Our Ref:239848
Department Ref: SSD-9827

**RE: PART LOT 4 DP 1238761
45 HONEYSUCKLE DRIVE, NEWCASTLE.**

Thank you for your letter dated 21 February 2020 providing the Departments request for additional information in relation to the above application following further assessment. Please accept this submission as our formal response to the matters raised.

Development Application

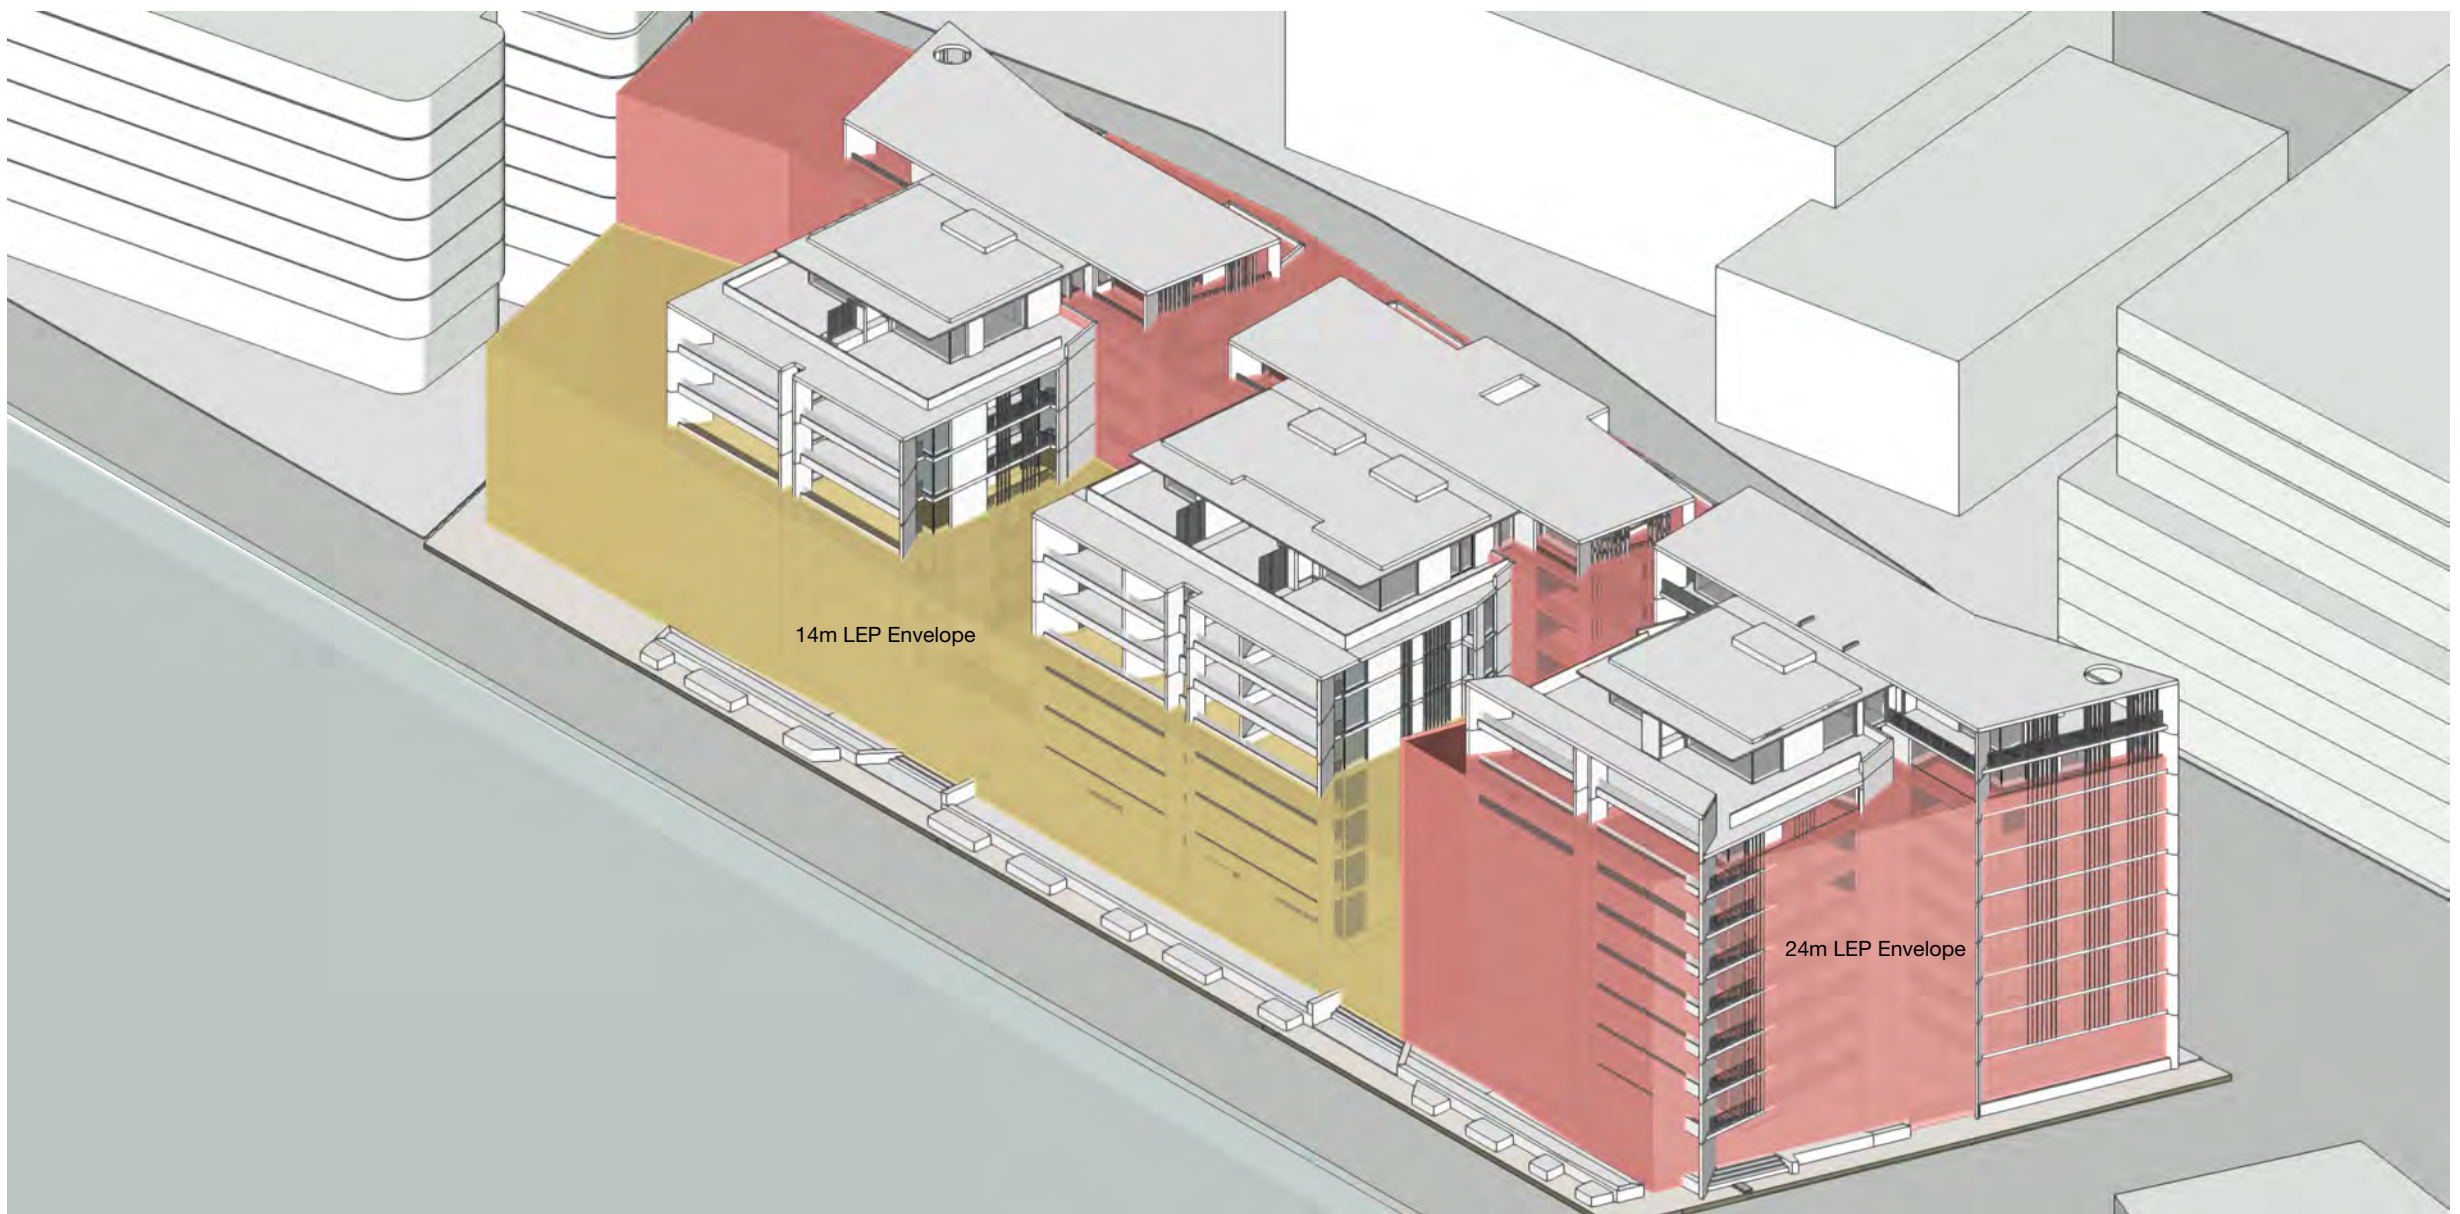
Provide an assessment of view loss impacts, using Tenacity Principles, to the residential apartments and hotel rooms of the approved development at 42 Honeysuckle Drive. The assessment should consider the current proposal as well as an LEP compliant scheme.

A typical built outcome on 45 Honeysuckle Drive would be one assumed to comply with the relevant planning provisions. In this regard, it is considered that a compliant development outcome would see the entire footprint of the site developed up the maximum height would have a greater impact on views from 42 Honeysuckle Drive than what is currently proposed.

However, because the proposed development footprint has been reduced and because a more slender built form with separation between the three (3) buildings the retained views from 42 Honeysuckle Drive are improved. Views from 42 Honeysuckle Drive will be available through the site and via the available space along the Cottage Creek corridor as shown on the below photomontage, which outlines a compliant scheme (in block form) and the proposed development.

Ground Floor Communal Space  
SCALE 1:388.99 @ A1

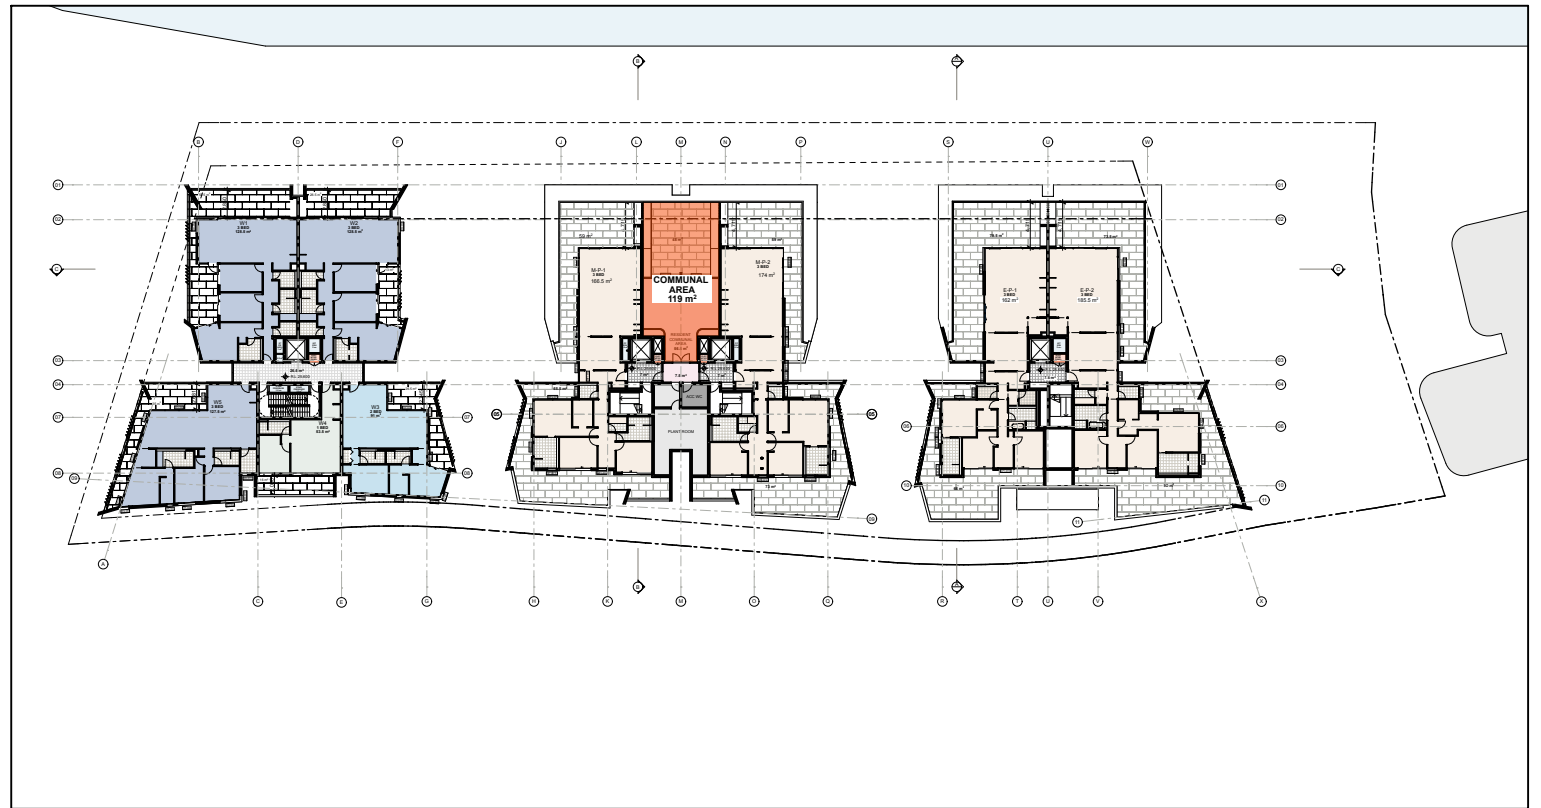
Further consideration of the communal open space is required, including:

- a. confirm sunlight access to communal open spaces during mid-winter.
- b. clarify the exact location (providing a plan and an itemised area schedule) of the 649m² communal open space.
- c. provide further detailed justification for the departure from the Apartment Design Guide (ADG) requirements. In particular, consider the objective, design criteria and guidelines for the communal open space provision.

- a) As shown on the Communal Open Space Solar Access Plan provided within **Appendix A**, the Communal Open Space areas receive adequate solar access during mid-winter.
- b) As shown on the Communal Open Space Solar Access Plan provided within **Appendix A**, the exact location of the communal open space has been provided along with an itemised schedule confirming the total areas of communal and public open space.

As detailed on the plans, the following areas have been provided:

- Private Resident Communal Area 816.5m².
 - Public Communal Area 1,102m².
 - Steel St Reserve 899m².
 - Total = 2,817.5m².
- c) Additional comments to the ADG requirements have been provided within **Appendix B** to specifically address the comments provided in point c) above.

Total area of dedicated private communal open space is 816.5m² or 14.5% of the site area. The total is 10.5% below the ADG requirement but is justified by the following items under the design guidance:

- Generous balconies to all units with most having more than 1 balcony.
- Extra facilities dedicated to the development with a gym and common room provided to the ground floor (124m² total space).
- Dedicated new Public Square to end of Steel Street to provide a pedestrian connection through to the harbour foreshore. This will be a high-quality open space that can be accessed by all residence as well as the public (899.5m²).
- There will be direct access to a high level of public open space along the Hunter River Foreshore.

If the areas of common facilities are included and the new dedicated Public Square, the total area of communal space is 1,840m² or 32.8% of the site area.
